TOMAGO ROAD (MR302): SSD 10447, RESOURCE RECOVERY FACILITY, LOTS: 8 & 11 DP: 270328, AND PART LOT: 301 DP: 634536, 21 D&F SCHOOL DRIVE TOMAGO

TfNSW has reviewed the Response to Submissions (RtS) by Jackson Environment and Planning dated 8 June 2021, and the submitted Traffic Impact Assessment (TIA) by SECA solution dated 28 April 2021. TfNSW raises concern that the TIA does not adequately address the traffic impact of

Figure 2-9 – AM peak traffic demands, intersection of McIntyre Road and Tomago Road

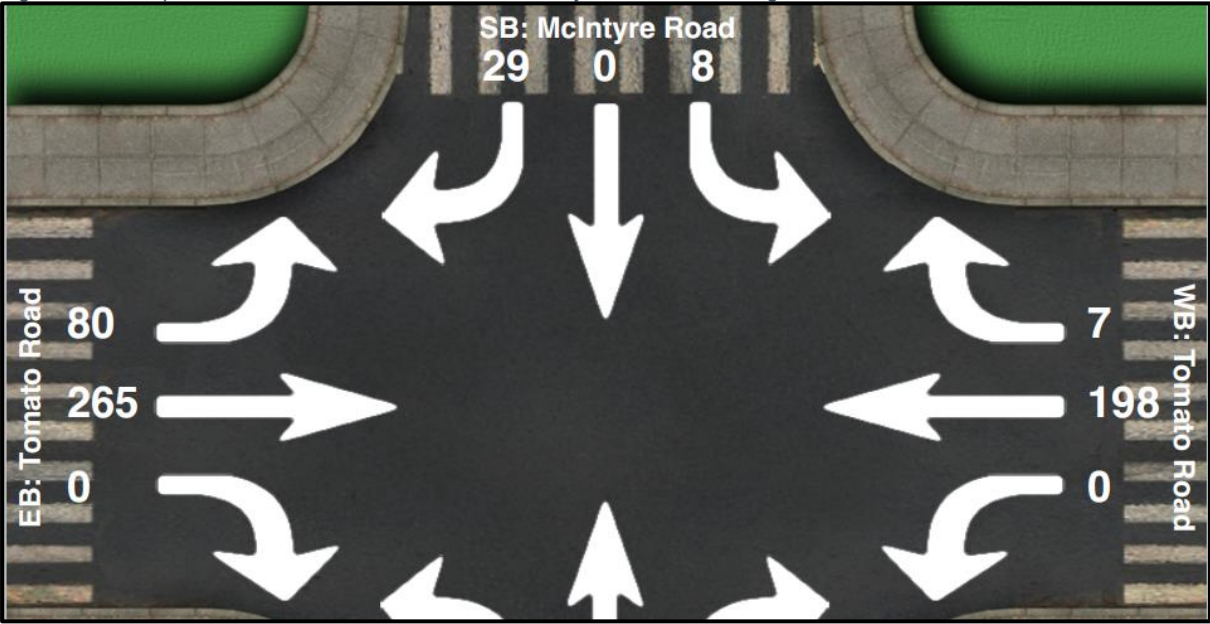
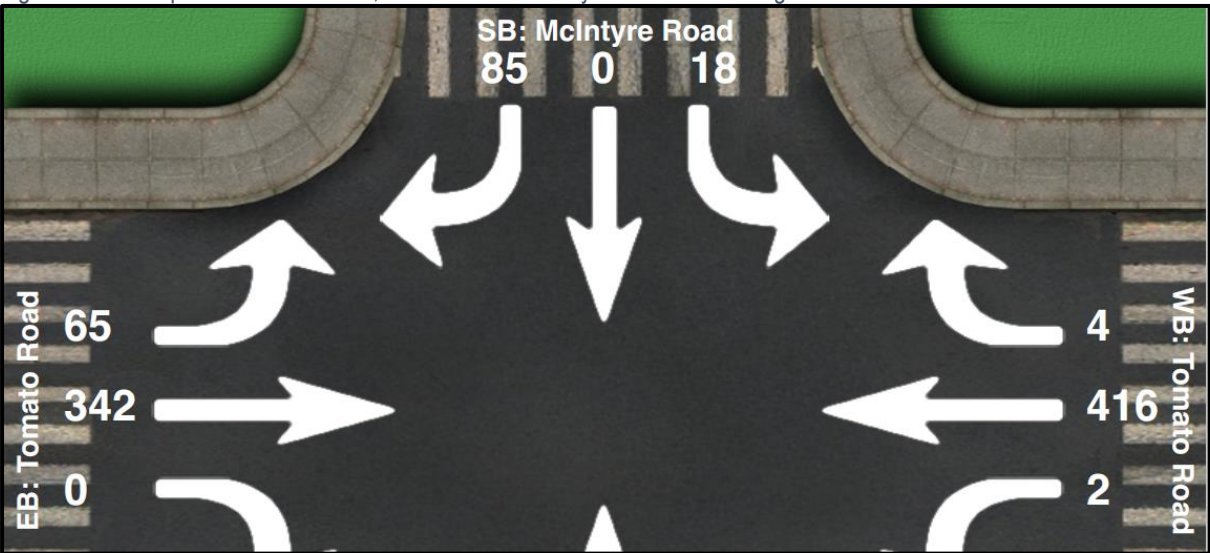
- That the traffic volumes collected are not relevant to understanding the existing traffic environment. The traffic counts for the Tomago Road and McIntyre Road intersection were undertaken on 6 July 2021, which was within the NSW school holiday period. It is considered that the surveyed traffic volumes would unlikely represent typical Tomago Road peak hour traffic volumes.

Accordingly, TfNSW recommends that DPIE require a revised Traffic Impact Assessment that addresses the above concerns.
